From: jamie@fenley.co.uk
Sent: 31 March 2021 17:19
To: Dominic Smith
Subject: RE: Ford Lane - RSA [Filed 01 Apr 2021 11:12]

Thank you for the email with the attachments to include your revised drawing ITB14679-GA-002 revision D.

Please can you confirm whether you are satisfied with the amendments proposed, or have any further comment. The alterations are presented in Drawing ITB14679-GA-002 Rev D.

**Summary:** Users will travel around the proposed staggered barriers on uneven ground

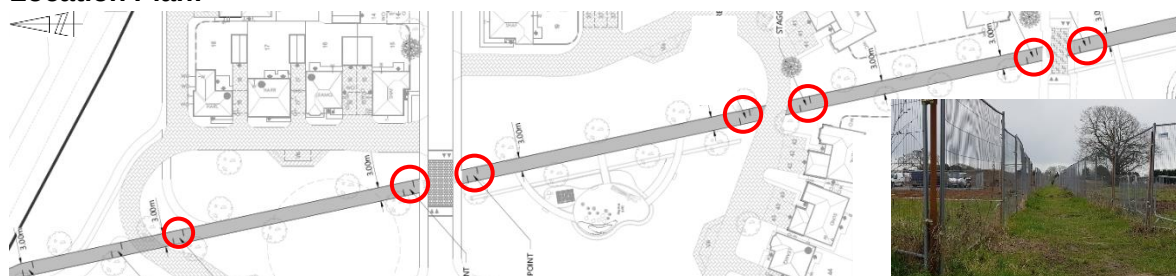
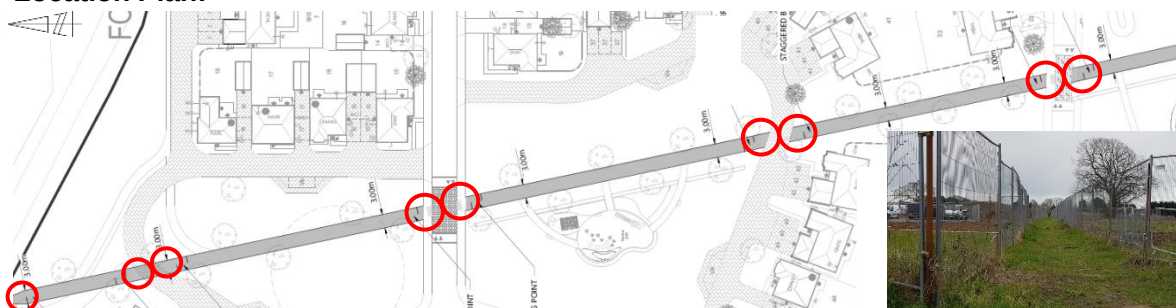
I understand that the existing steps are to be replaced with a slope down to the carriageway as part of a S278 Agreement and as such, there is no reason to deter cyclists and addresses item B.2.1 that was raised within our road safety audit, reference RSA-20-193-3. As a slope is to be present, we do not see a reason to reduce the width of PRW 357 from the desired 3 metres to 2 metres provided the staggered barriers remain and measures are provided to ensure that pedestrians and cyclists do not bypass the barriers. I have not been provided with details of the associated S278 works but as they have been or will go through the Technical Approval process, it can be assumed that the slope will be set at an appropriate gradient to reduce the likelihood of trips and falls.

Problem B.2.1 – the audit identified measures to mitigate the hazard posed by steps being in situ. The S278 Drawings relating to works on Ford Lane include the removal of the steps and replacement with a slope. As the recommendation was to narrow the footway to 2m to discourage use by cyclists due to the presence of the steps, we have amended the design to reinstate the width to 3m before narrowing to tie in with the approved works since the step hazard no longer exists.

**B.4.2 PROBLEM**

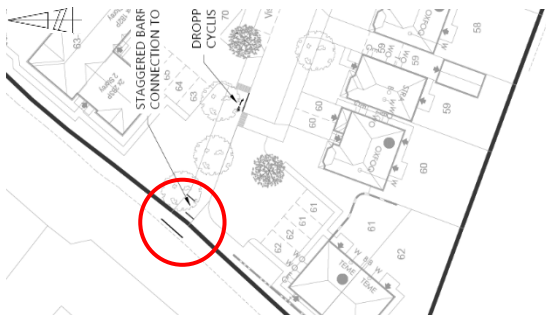
The provision of dropped kerb to the east of the site on North End Road will allow level access between the carriageway and shared footway cycleway and addresses item B.4.2 of our road safety audit, reference RSA-20-193-3. It is however, recommended that the 'CORDUROY PAVING AND START / END OF CYCLE ROUTE SIGNAGE' that was proposed within the site, is provided on the footway either side of the dropped kerb to ensure that pedestrians travelling along the North End Road footway, become aware of the potential for cyclists crossing their path.

Problem B.4.2 – while comments regarding a level transition onto North End Road did not form part of the recommendation (works on the highway have been subject to a separate approval process and are outside of the scope of the Audit), the comments of WSCC are noted and the design has been amended to identify that a level transition will be formed by the introduced of a dropped kerb arrangements. These measures can be constructed as part of the S278 works and the change recorded as part of the ‘as-built’ drawings.
